Planning Consultation Memo

Date: 25 April 2022	Planning Officer: Louise Sahlke	Landscape/Tree Officer: Oliver Waring
Planning Application Number	<u>6/2021/2125/MAJ</u>

Context	
Site Address	Hertfordshire Constabulary, Stanborough Road, Welwyn Garden City, AL8 6XF
Relevant Constraints/Policies	<p>WHDP 2005</p> <p>R11 – Biodiversity and Development – all new development will be required to demonstrate how it would contribute positively to biodiversity of the site by retention and enhancement of the natural features on site.</p> <p>R17 – Trees, woodland and hedgerows – the council will seek the protection and retention of these features and require when appropriate new, native planting.</p> <p>D8 – Landscaping – the council will require the retention and enhancement of existing key landscape features (requiring detailed surveys)</p> <p>Policies from the Draft local plan -</p> <p>SP11 – Protection and enhancement of critical environmental assets – protection, enhancement and management of the environmental, ecological and historical assets within the borough, will be sought commensurate with their status, significance and international, national and/ or local importance.</p> <p>SP12

**Proposed Site Landscaping Plan**

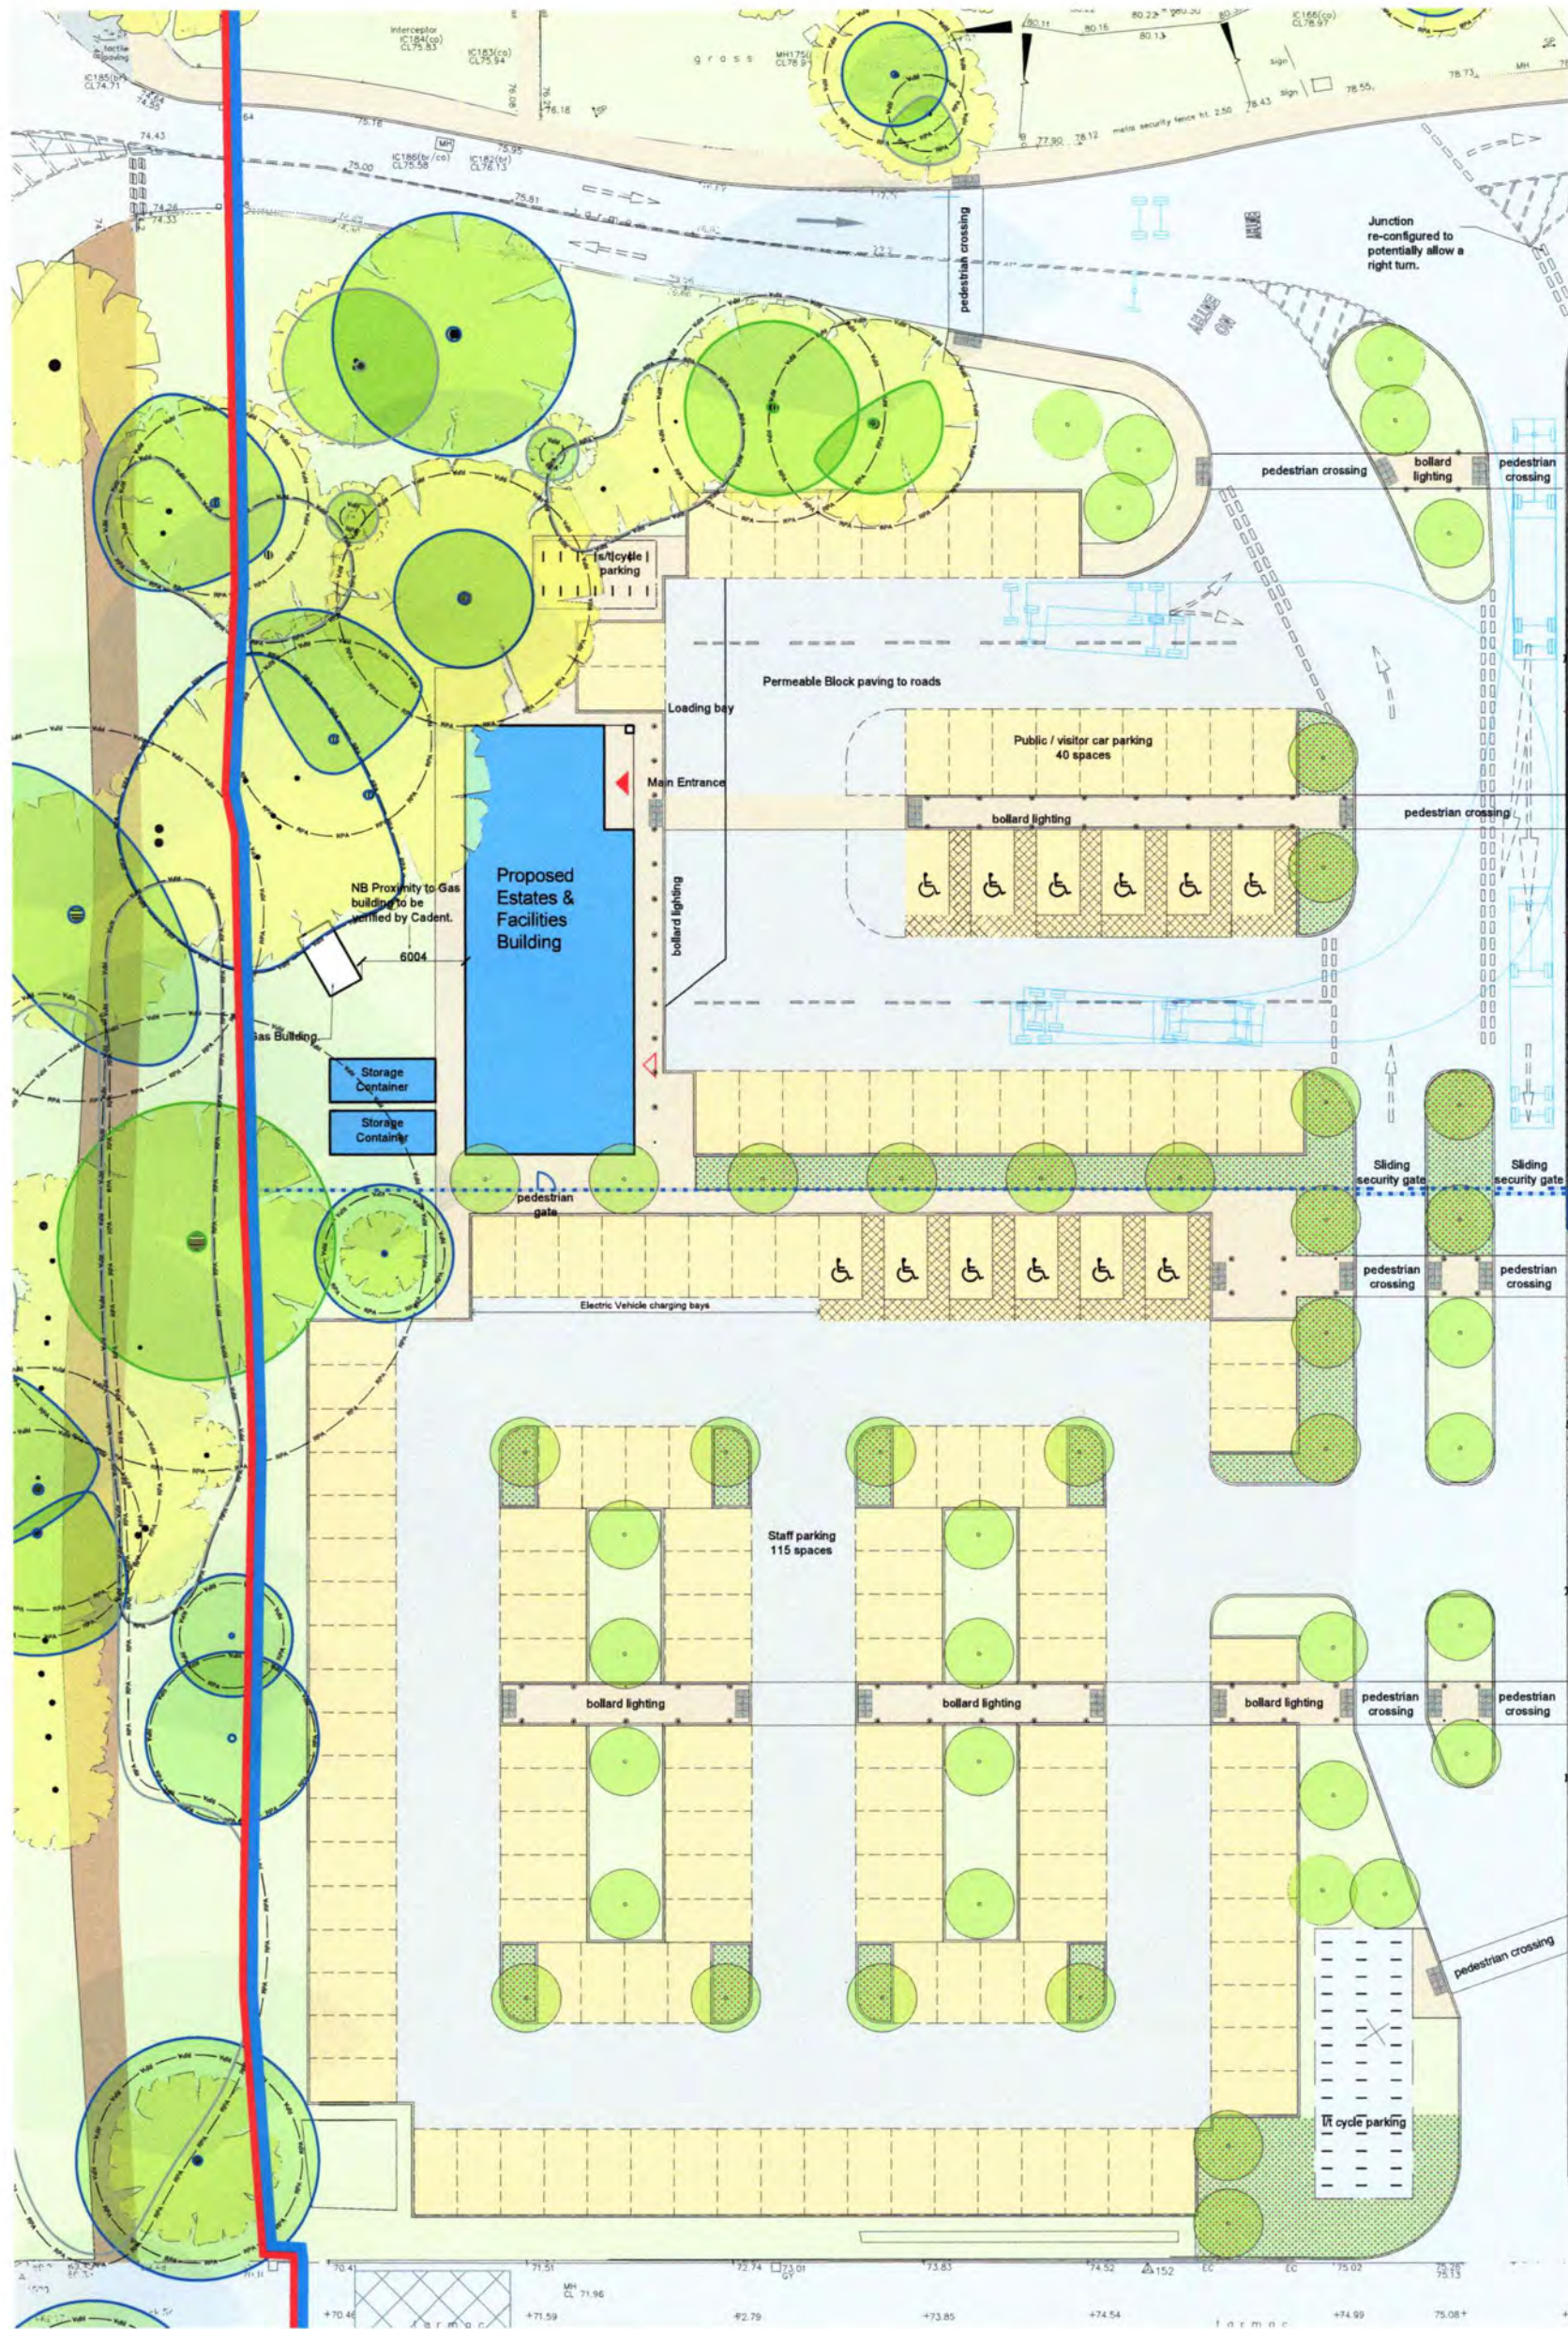
A Proposed Landscaping Plan has been provided. This provides some detail of proposed hard landscape and indicative soft landscaping. If approved a detailed landscape plan would be required via condition. This would need to include proposed species, plant sizes, planting densities, planting methods and aftercare.

In principle, from a landscape perspective, there is no objections to the proposal. Some trees removals are required to facilitate the development; however, most of the tree removals are internal to the site and can be mitigated through a robust landscape scheme. A Proposed Landscape Plan has been provided and outlines the planting principles; further details will be required via condition.

- Tree Protection details for the construction and use of the temporary access route and compound within the Gosling Site
- A detailed landscape plan to include. species, plant sizes, planting densities, planting methods and aftercare.

SHEET TITLE
TREE CONSTRAINTS PLAN
(Sheet 01)

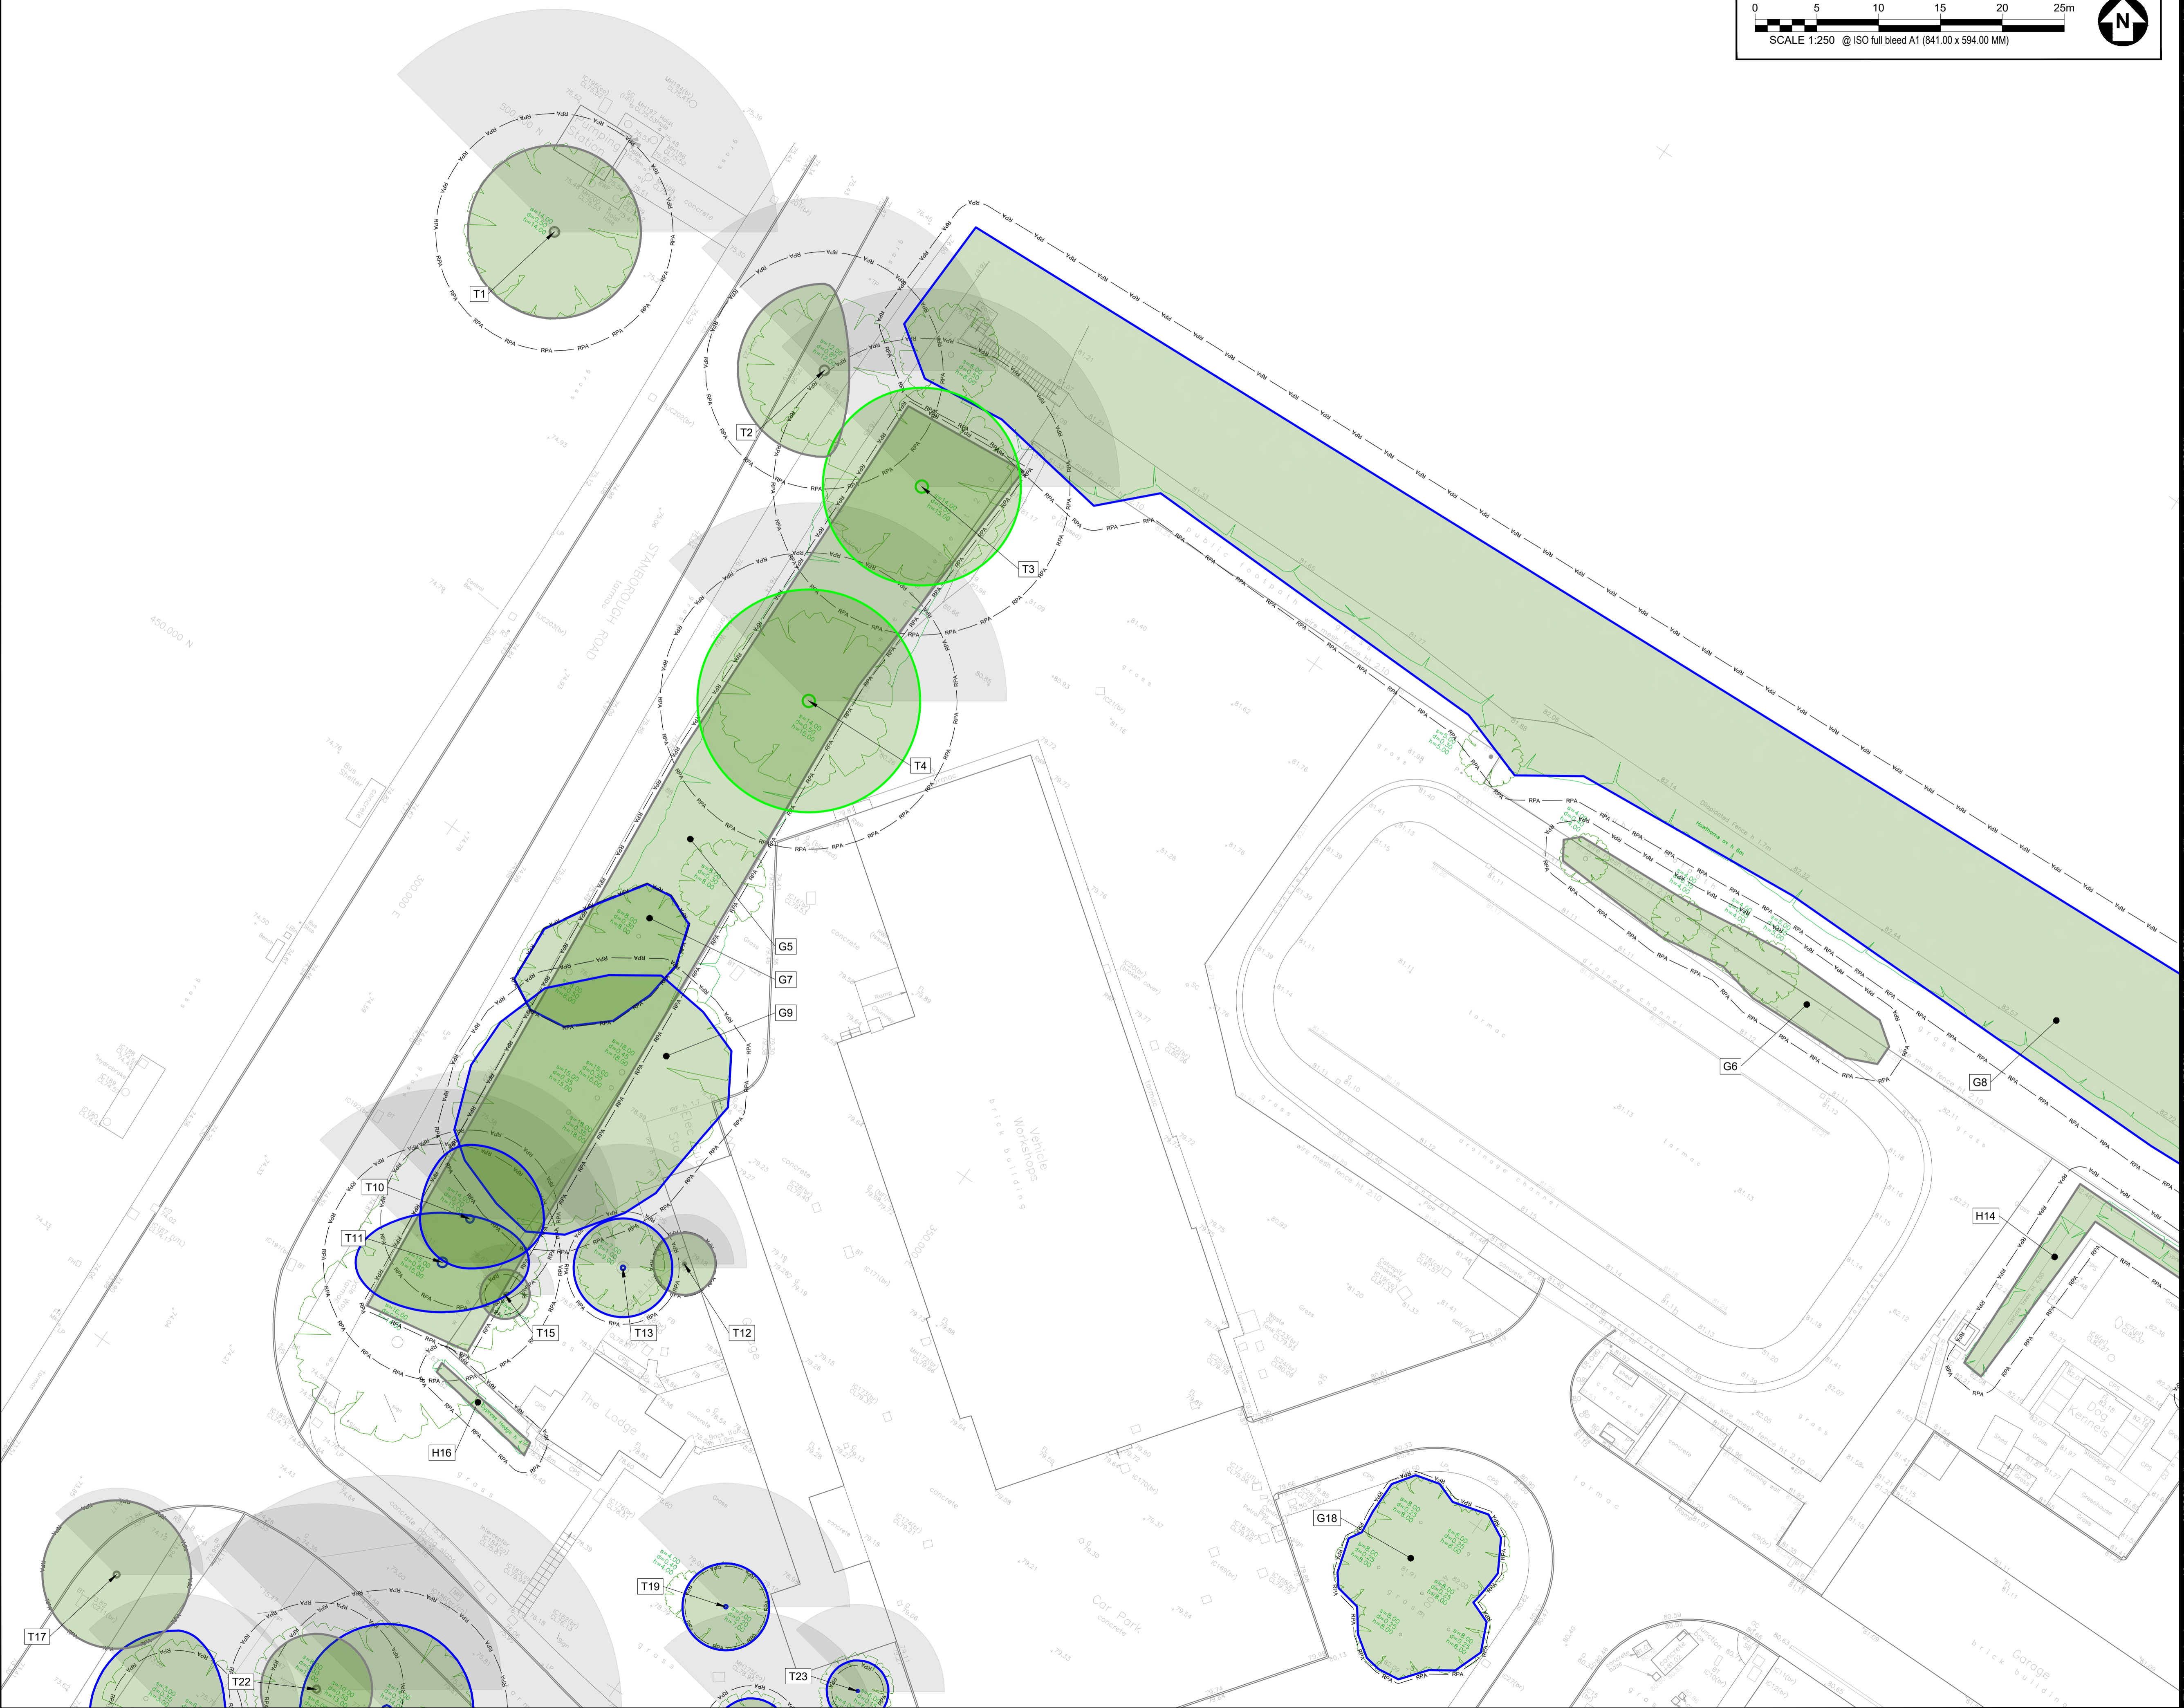
Comment (if applicable): A Tree Survey and constraints plan, in accordance with BS:5837:2012, by AECOM has been provided.

An Arboricultural Impact Assessment and Tree Protection Plan has also been provided. The Tree Protection Plan does not include the proposed new access road. It is noted that Temporary contractor's compound is to be located adjacent to the access road. If approved details of any tree protection required during the construction and use of the road and compound should be requested via condition..
